Pilcot Mill Refurbishment

Comments and Suggestions

Post Visit on 23 Feb 2023

Ivor New
David Plunkett
Rev: 2 14/4/23

FIRST FLOOR PLAN

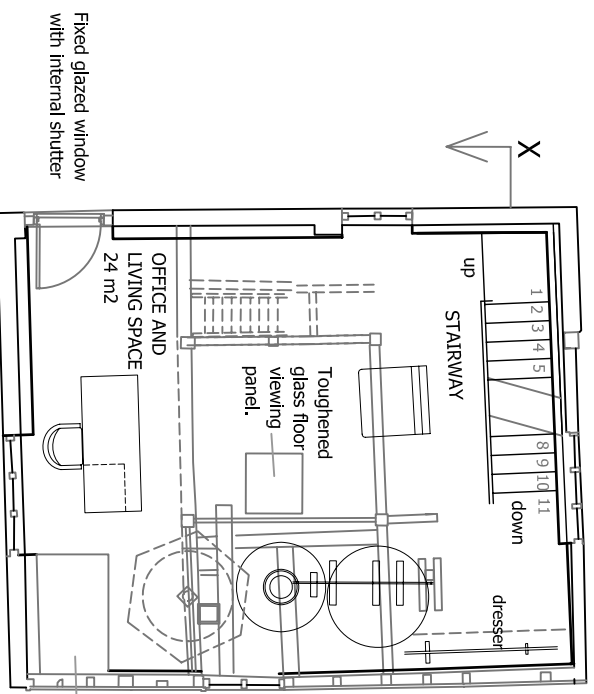
- It is suggested that to provide a flat and interesting floor the first bed stone should be set down into the floor to become flush with its surface. The beams that support the stone should be inspected first but in most mills these beams, designed to take the weight of two stones and a rotating load, should be strong enough to support a single static stone, even when reduced in depth. Consideration should also be given to ensure the integrity of the mill equipment on the ground floor is retained.

- It was agreed that the Sack Hoist Traps* should be retained but it is suggested that a board should be fixed from below to hold the traps shut and also cover the hole for the hoist rope.

- It was agreed that the second millstone set, should be repaired and form the centre piece of the internal display. This would require the runner stone to be put back into place, the tun to be repaired and a new hopper being made, together with other missing items. It is suggested that the exposed woodwork should be painted with a good quality spar varnish that would seal the surface

- On later consideration of the wooden frame/box in front of the second stone it was realised that it was almost certainly a grain cleaning machine***. It is missing the sloping, rotating internal cylinder and brushes that would normally be inside. The surface of this cylinder would be clad with a wire mesh that is smaller than a cereal grain. When in operation grain is fed slowly but continuously into the upper end of the cylinder which brushes the grains against each other which loosens chaff, other small particles and contaminants which then fall through the screen to be collected in the machine's outer box to be disposed of later. The clean grain falls out of the end of the cylinder into a hopper and is ready for milling. As a fundamentally important part of the mill it is suggested that this is retained, probably repositioned and possibly used as a display cabinet to house explanatory display boards and any relevant small items associated with the mill.

- To the left of the smutter there is the partial frame of what seems to be a flour dressing machine. This could have provided an example of the other essential machine that is currently missing. This machine separates the meal produced by the mill into differing grades from fine flour to bran. This would allow the museum to show the whole process of taking grain from the farm to sending flour to the baker.

GROUND FLOOR PLAN

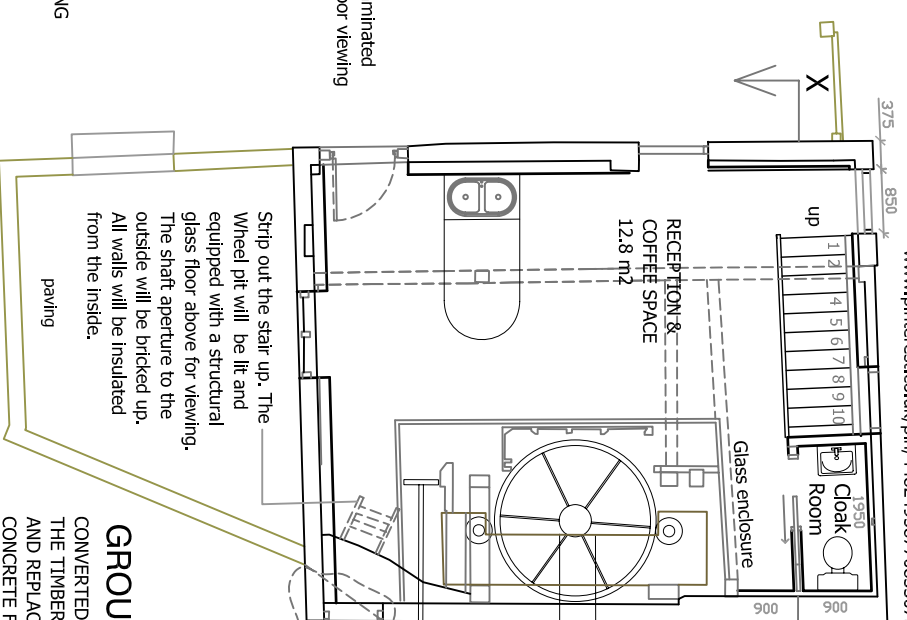
- The core milling equipment is essentially complete and is contained within the hurst frame*. Although the machinery is present it is very rusty and most of the wooden cogs are missing. It was agreed that, as the axel port was open to the elements, the hurst frame should be glazed to provide a display case which would separate the machinery from the accommodation. It is suggested that the glazing on the side away from the door should comprise double hinged doors to allow easy access to the machinery.

- On the way up the stairs Kim drew attention to the lack of insulation on the wall. It was agreed that the practical solution would be to add an inner skin to the studding wall and fill the resulting space with insulation. If this is done, consideration should be given to providing vapour barriers to ensure that neither condensation from within the building nor moisture ingress from outside occurs in such a damp environment. It was also suggested that thin strips of suitable timber should be applied to the internal surface of the lining to replicate the impression of the current wall.

- It was only noticed later that the reason for the staircase landing, was to give access to the door out to the walkway above the sluice gate. It is suggested that the door should be glazed to provide extra light in this area as well as the facility to access the (currently incomplete) external walkway. This would not only be a beneficial amenity as it gives a fine view of the wheel, the river and the local landscape, but also necessary to retain the essential pathway by which the miller would have access to, and with the door ajar, a view of the wheel and sluice when the mill was operating. This area is important for the integrity of the mill as it is at the core of the mill's access and controls.

It is understood that in future there will be alternative access to other floors so it seems the priority in this area is to the museum aspects of the project. It is suggested that this could be achieved by removing much of the central part of brick landing leaving only low walls around three of its sides. To indicate the historical use of this area the steps to the first floor could be fixed to the left hand wall above that remaining part of the old landing. A new cill could be fixed in front of the refurbished door/ window, and the remaining right hand side would stay to support the adjacent external wall. The low steps to the landing would be converted to a 'library step' format that could be used to access the door/ window. Or even, with some plant trays, become a decorative item!
